**Application by Highways England for an Order Granting Development Consent
for the A38 Derby Junctions Project**

Issue Specific Hearing 2: Submissions on Behalf of Derbyshire County council

The Examining Authority's Issues and Questions for Issue Specific Hearing 2: Issued on 3rd December 2019

Written Summary of Oral Contributions at Issue Specific Hearing relating to the Draft Development Consent Order on 11th December 2019

Drawing Title  
FIGURE 2.7  
LITTLE EATON JUNCTION  
GENERAL ARRANGEMENT

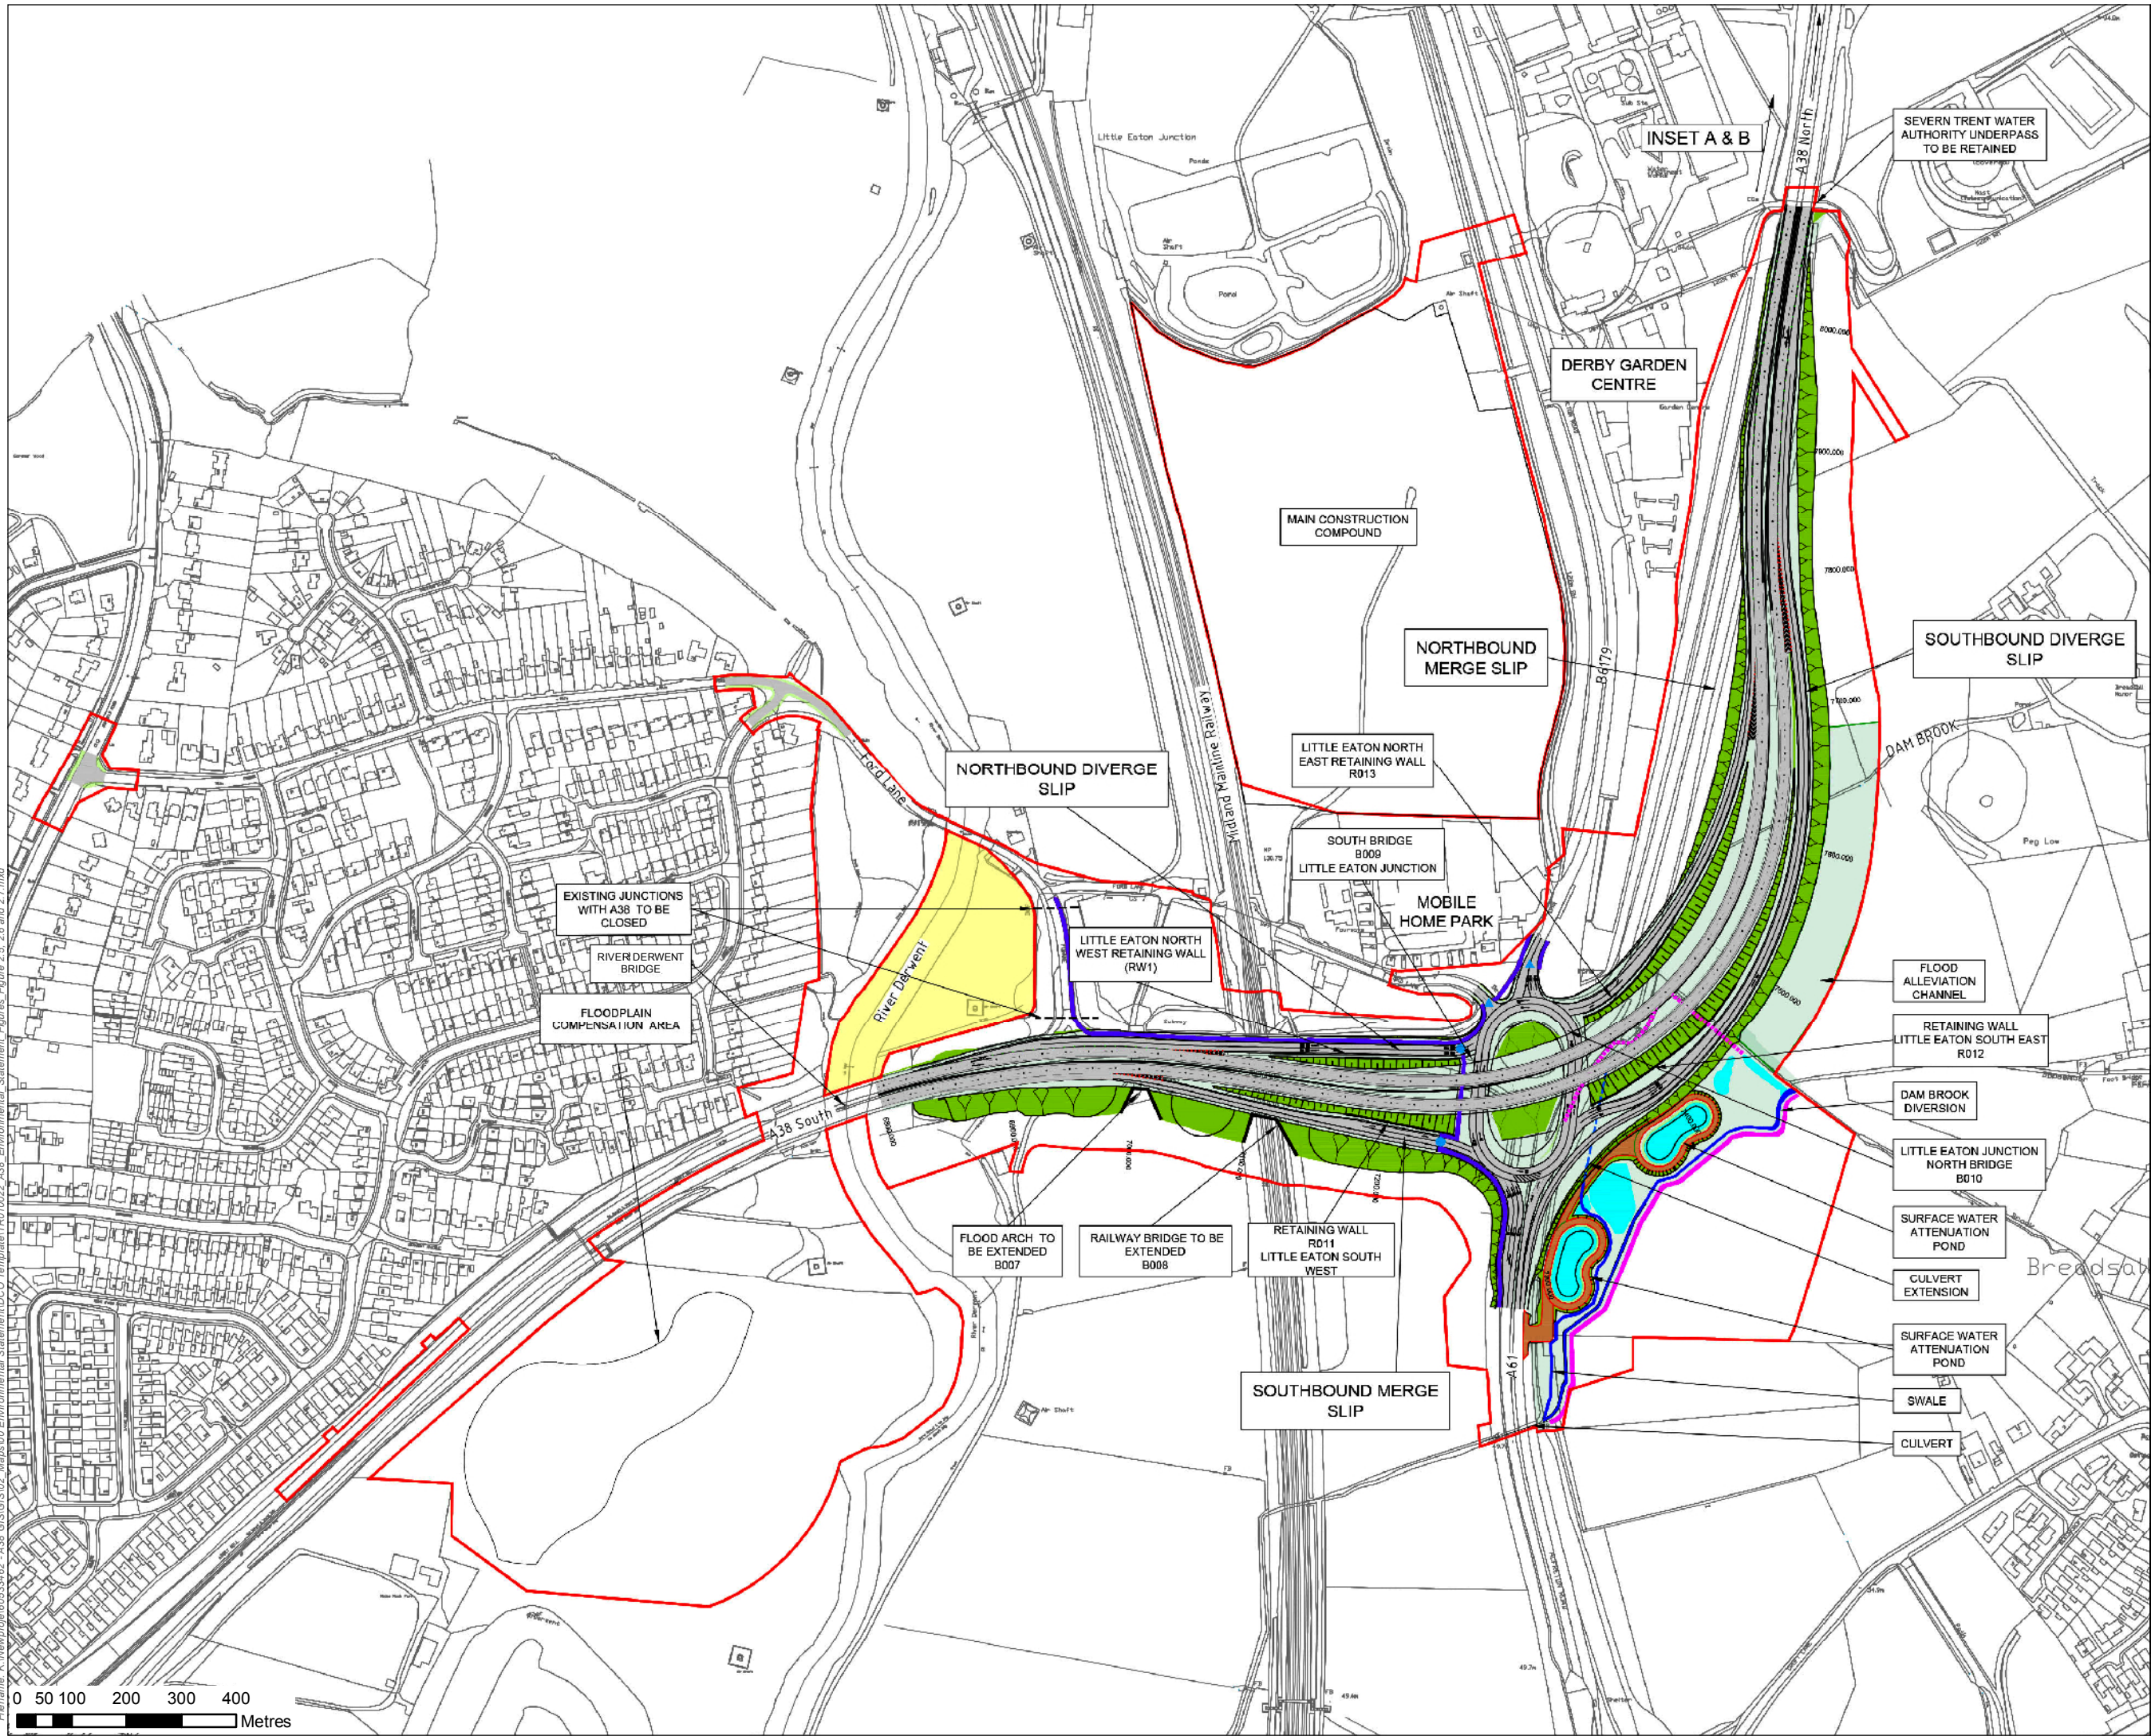
- 2.3 With regard to landscape character, Derbyshire County Council’s original position was that it found it difficult to accept that a large embankment crossing the floodplain compounded by proposed planting along the proposed embankments would only be likely to have a ‘slight adverse’ effect when this was clearly an incongruous landscape feature that blocked off the natural connections and functionality of a linear landscape. Other environmental mitigation proposals such as noise barriers and flood attenuation measures would also be perceived as alien features in the landscape that would further contribute to adverse landscape effects.

- 2.4 Visually the current junction benefits from being well screened by existing vegetation between the site and visual receptors around the site that are exposed to views of the junction. Although much of this vegetation would be retained and protected during the works, Derbyshire County Council considered that without visualisations, it was difficult to appreciate to what extent this vegetation would provide similar mitigation to the proposed grade separated junction on a high embankment. At the same time the ability to appreciate the flat, low-lying nature of the floodplain, important as both a landscape characteristic and as an attribute of the WHS, was not acknowledged in the applicant’s assessment and as a result had led, in the County Council’s opinion, to an under-assessment of visual effects. Trees proposed adjacent to the road and on the embankments would further compound the visual blocking of views through the Riverside Meadows landscape rather than contribute to mitigation and other proposed environmental mitigation could add to the visual clutter of the scheme. Although the Environmental Impact Assessment had considered alternative junction arrangements, Derbyshire County Council had originally considered that none of these had considered the use of a simple, elegant viaduct that would cross the flood plain without the need for embankments allowing the landscape and associated habitats to run below it.

- 2.6 Following the meeting with Aecom at Cromford Wharf on 5th December 2019 and the meeting of 28th November 2019 at County Hall in Matlock, it is the County Council's view that many of its concerns with regard to the assessment of landscape and visual effects have been allayed as a result of the additional information they have provided. The most significant information provided by the applicant (through Aecom their agents) is the submission of visualisations from various vantage points around the proposed new junction, including some of the viewpoints included in the LVIA, to highlight the overall design of the junction and the potential effect of the proposed mitigation. Whilst the County Council still believes there was still some merit in exploring the use of a free standing viaduct that would allow the landscape (and potentially habitats) to flow through the junction, the visualisations and the County Council's officer's subsequent site visit demonstrate that many of the adverse effects associated with the A38 crossing the floodplain already exist with the presence of sizeable embankments to facilitate the existing crossings of the River Derwent and the Midland Mainline railway. The photomontages demonstrate that the proposed new embankments would not be significantly higher than the existing embankments and in that regard views from the selected locations would not be noticeably different from the current view in the fullness of time when the proposed mitigation planting has become established. The LVIA acknowledges that during the construction phase, landscape and visual effects would be significant but would become moderate adverse on completion of the works and slight adverse 15 years post development when planting has become established.

- 2.11 As set out in its Written Representations and Local Impact Report, Derbyshire County Council had originally considered that the likely impact of the Little Eaton Junction scheme on the openness of the Green Belt, was intrinsically linked with the visual impacts of the scheme on the landscape and landscape character of the area and impact on the OUV of the DVMWHS. It considered that the junction improvements broadly accorded with national policies in the National Policy Statement for National Networks (NPSNN) and the National Planning Policy Framework (NPPF) for development of nationally significant infrastructure projects within the Green Belt and would not fundamentally undermine the openness of the Green Belt and main Green Belt purposes. However, Derbyshire County Council considered that the visual impact of the scheme could be significantly reduced by revisions to the design of the scheme, particularly the provision of an elegant viaduct to cross the floodplain rather than the extensive incorporation of embankment to carry the scheme over the floodplain.

- 2.7 In light of the additional information provided and the recent discussions with the applicants agents, the County Council's general view now is to concur with that judgement and on reflection there are other issues associated with delivering a viaduct that could impact on the general amenity of local communities in the immediate area such as issues around visual amenity and noise attenuation.

scheme would have no materially greater impact on the openness of the Green Belt than the existing junction scheme and that the openness of the Green Belt would be preserved.
